PLANNING AMENDMENT

PLOT 5, OFF ROMAN RD, MOUTON CHAPEL.

Description: Erection of house and garage
(Plot 5)

Amendment: Sun lounge, conversion of garage to study and repositioning
of rear first floor window (Dwg. No. DGM-MC.2/3D & 5B)

AMENDED PLAN

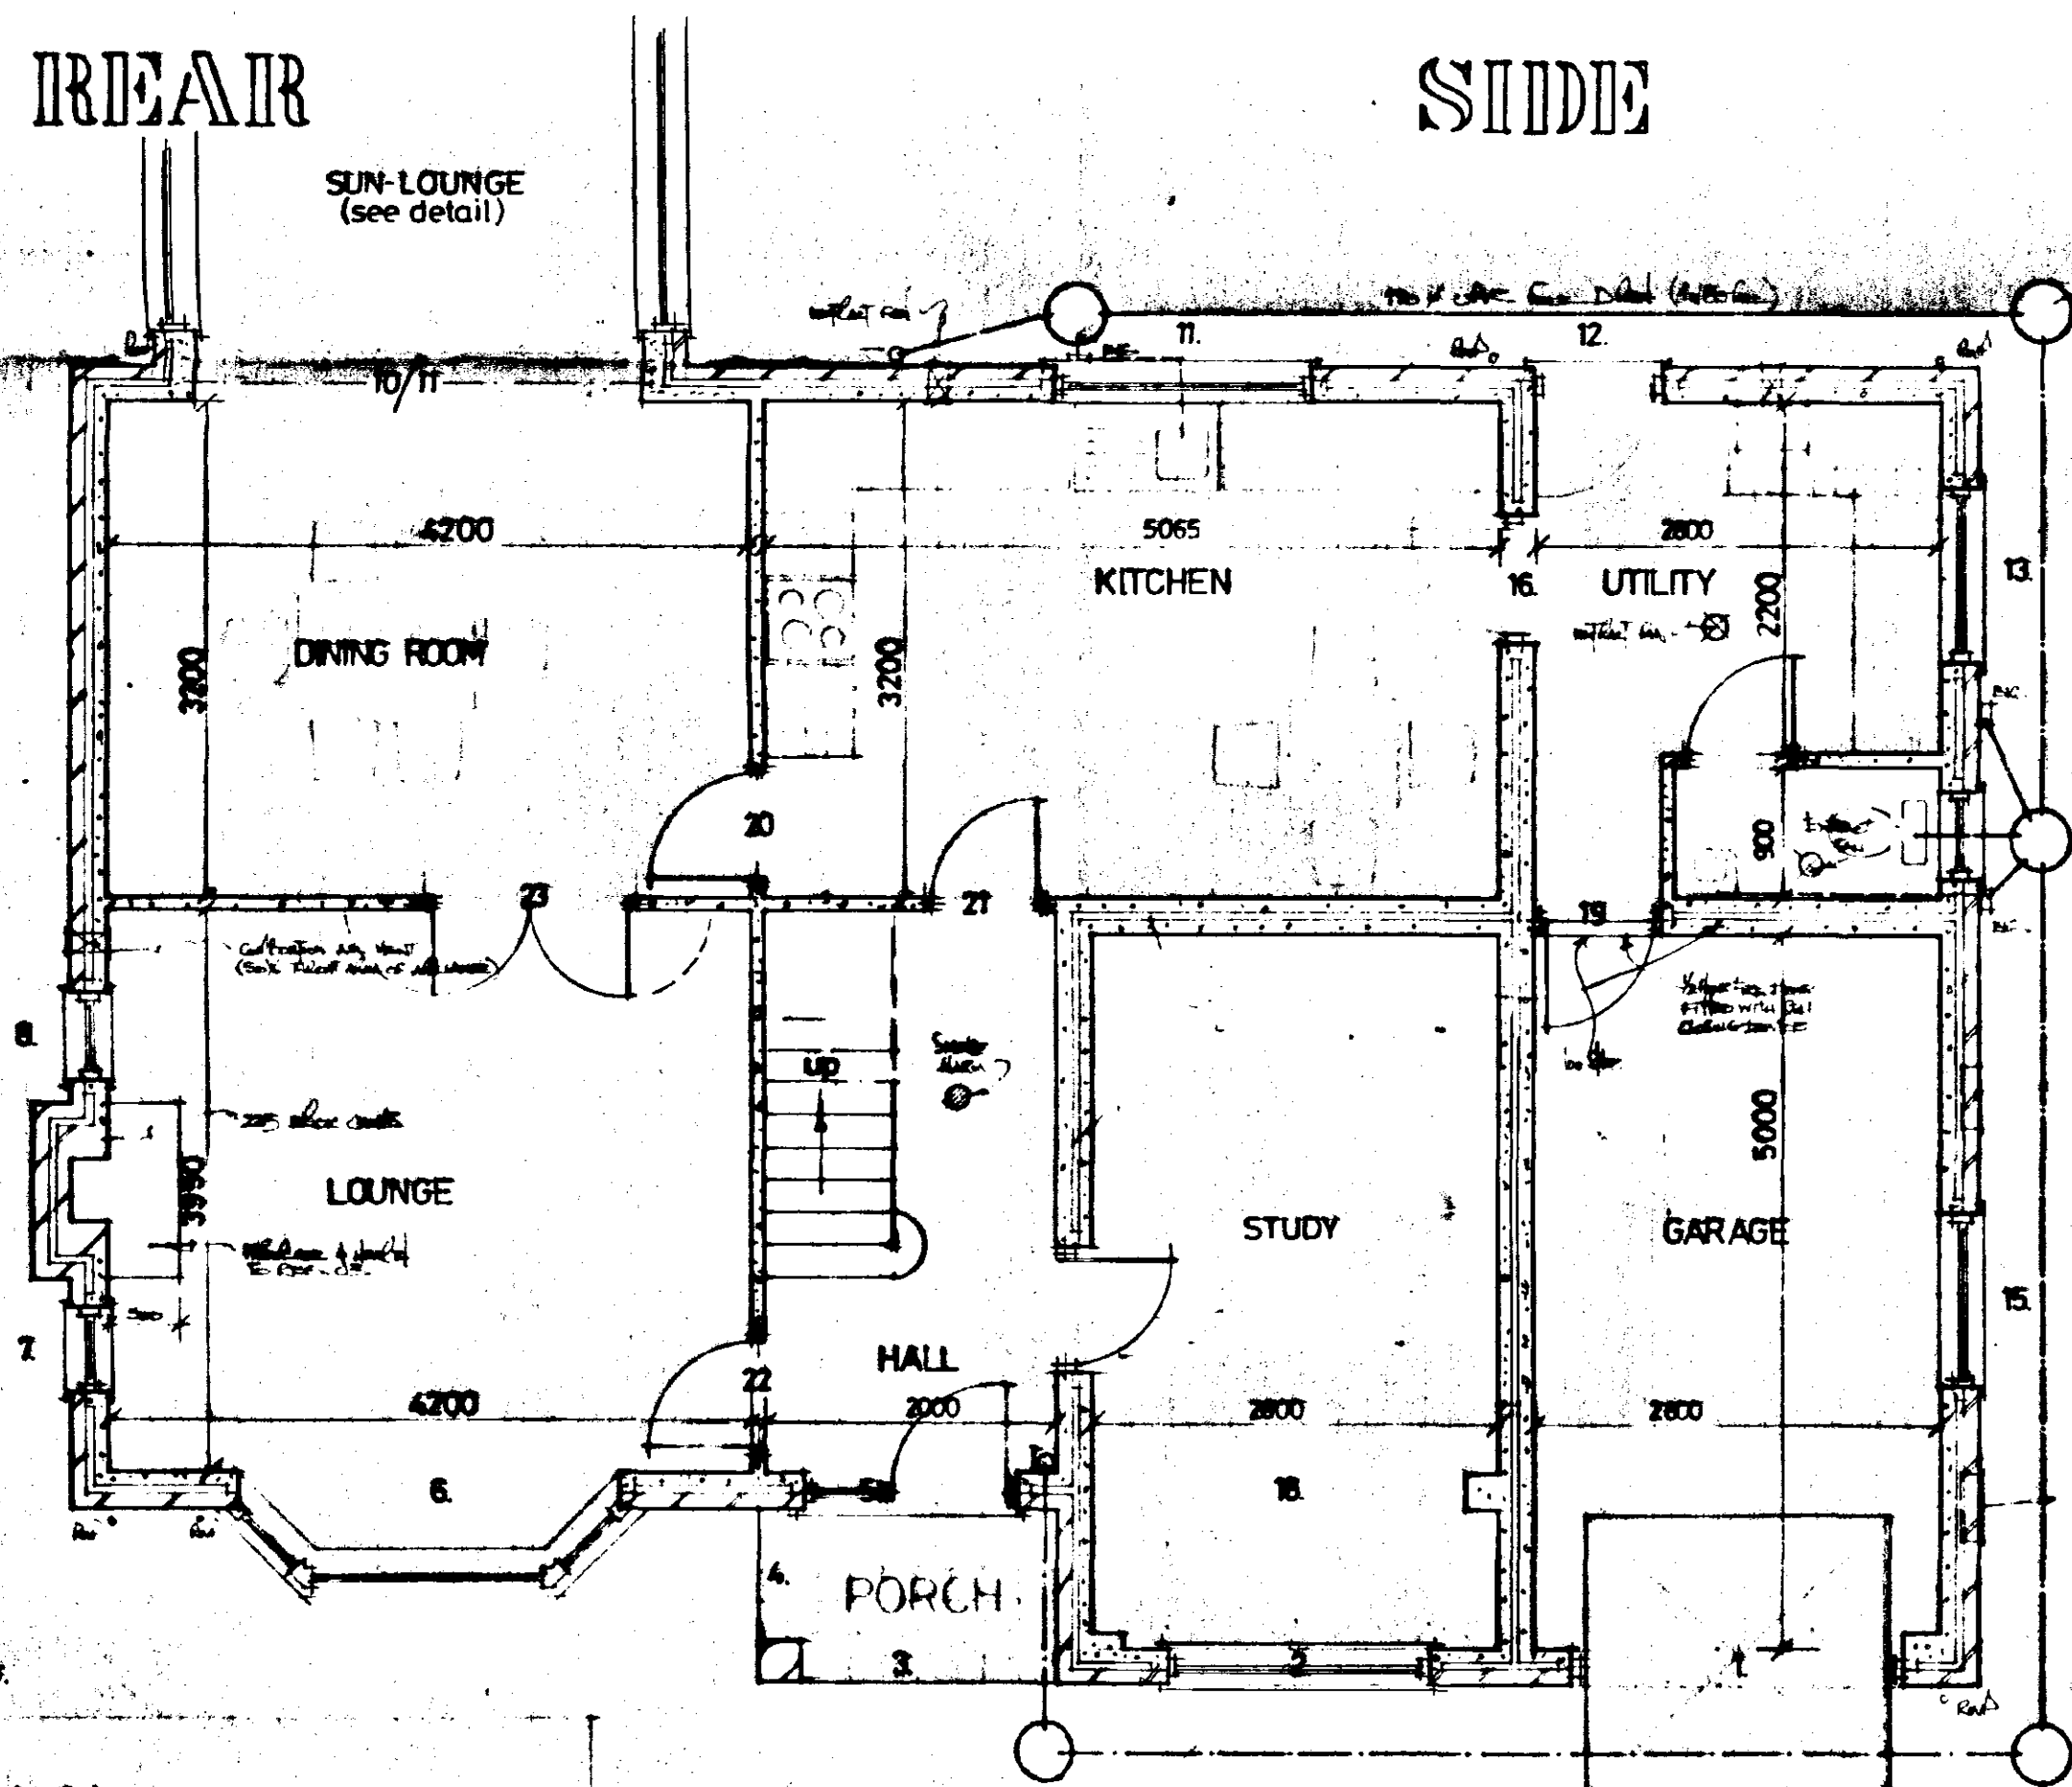
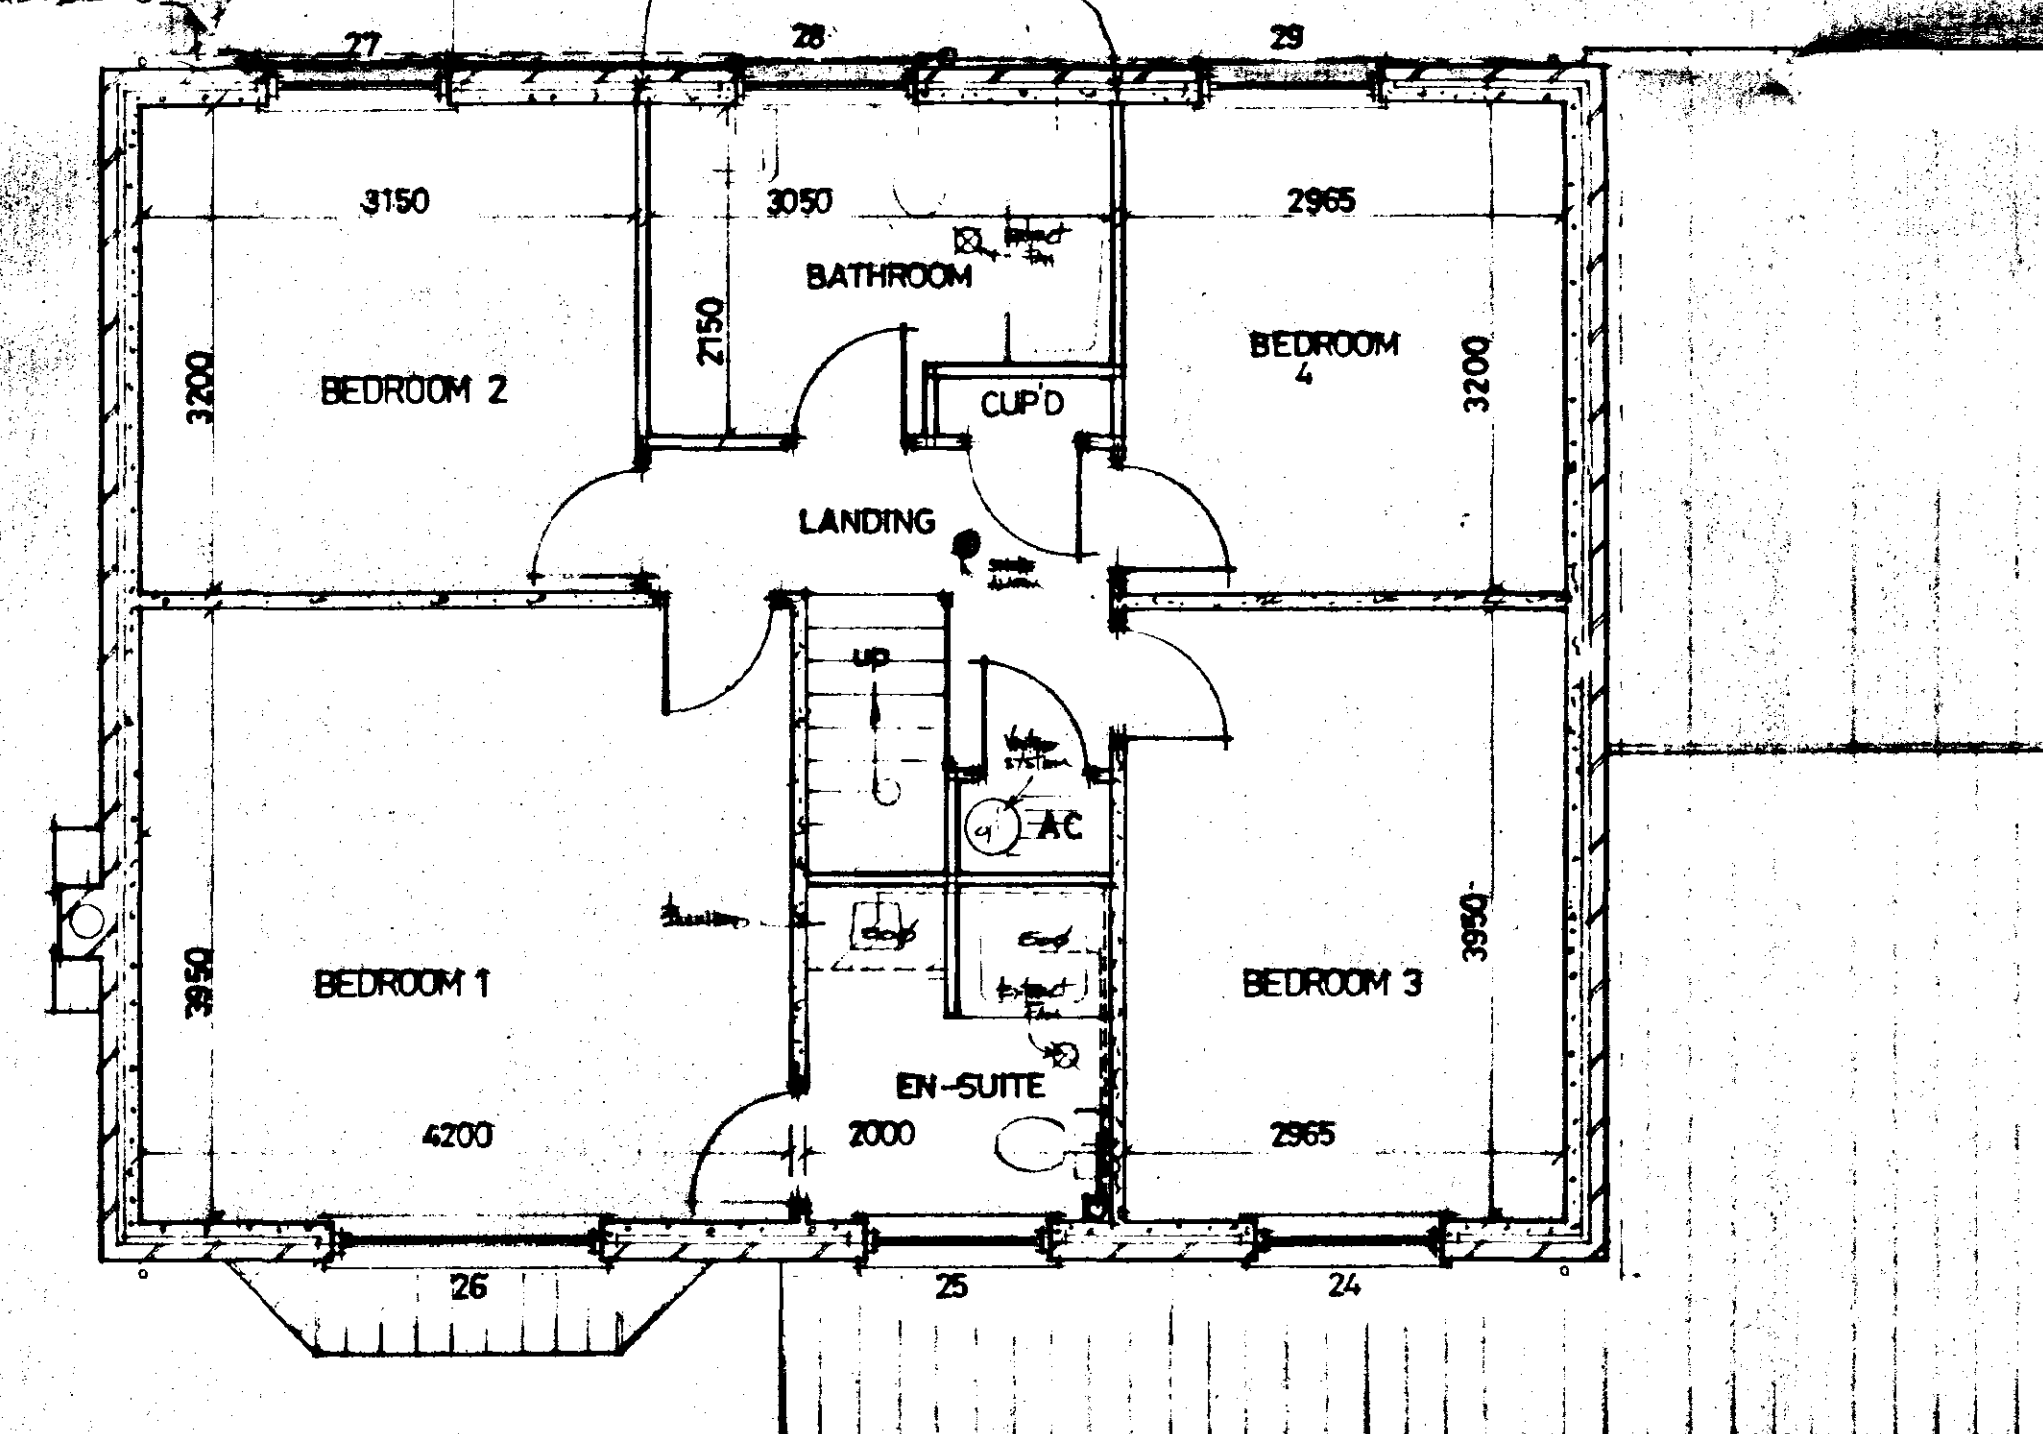
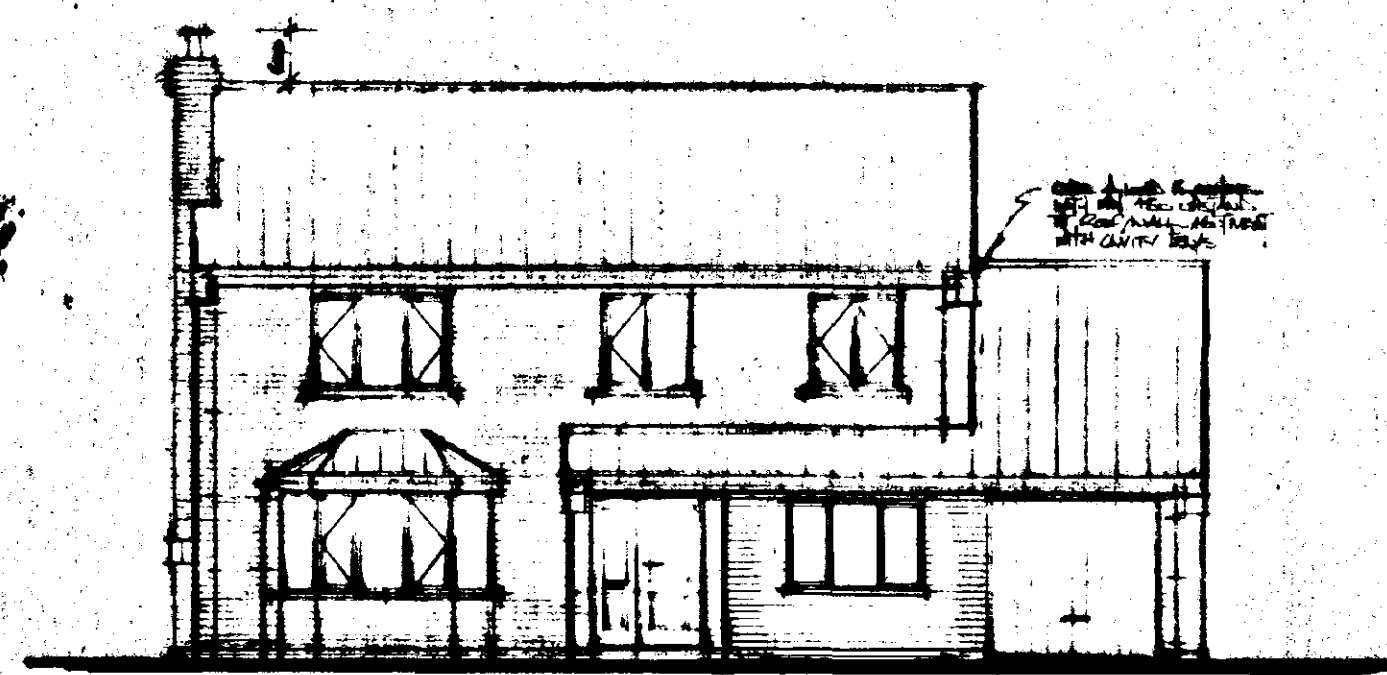
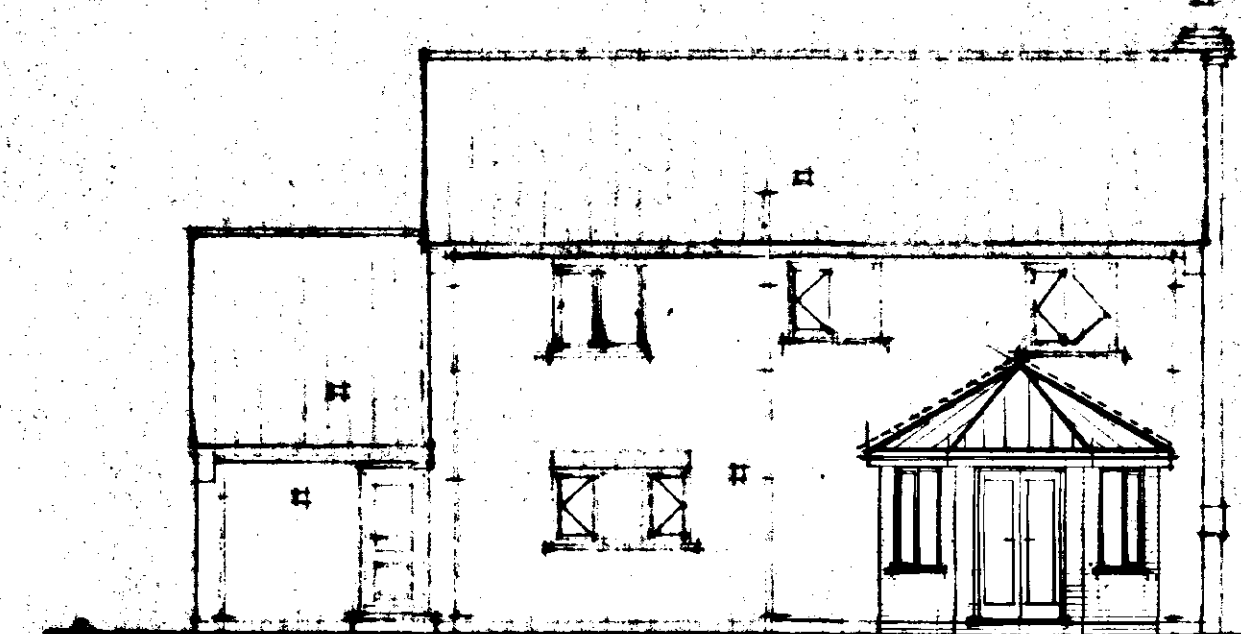
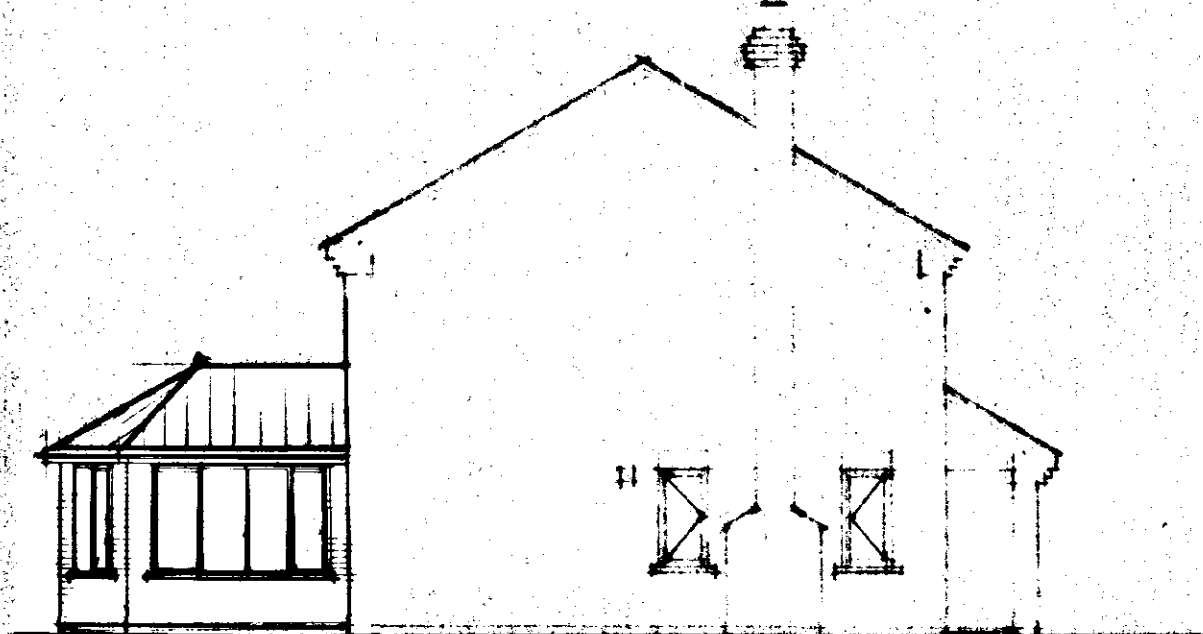
SUN-LOUNGE & GARAGE TO STUDY

Small change, ~~and~~ correction of going to study and
repositioning of some first floor windows.
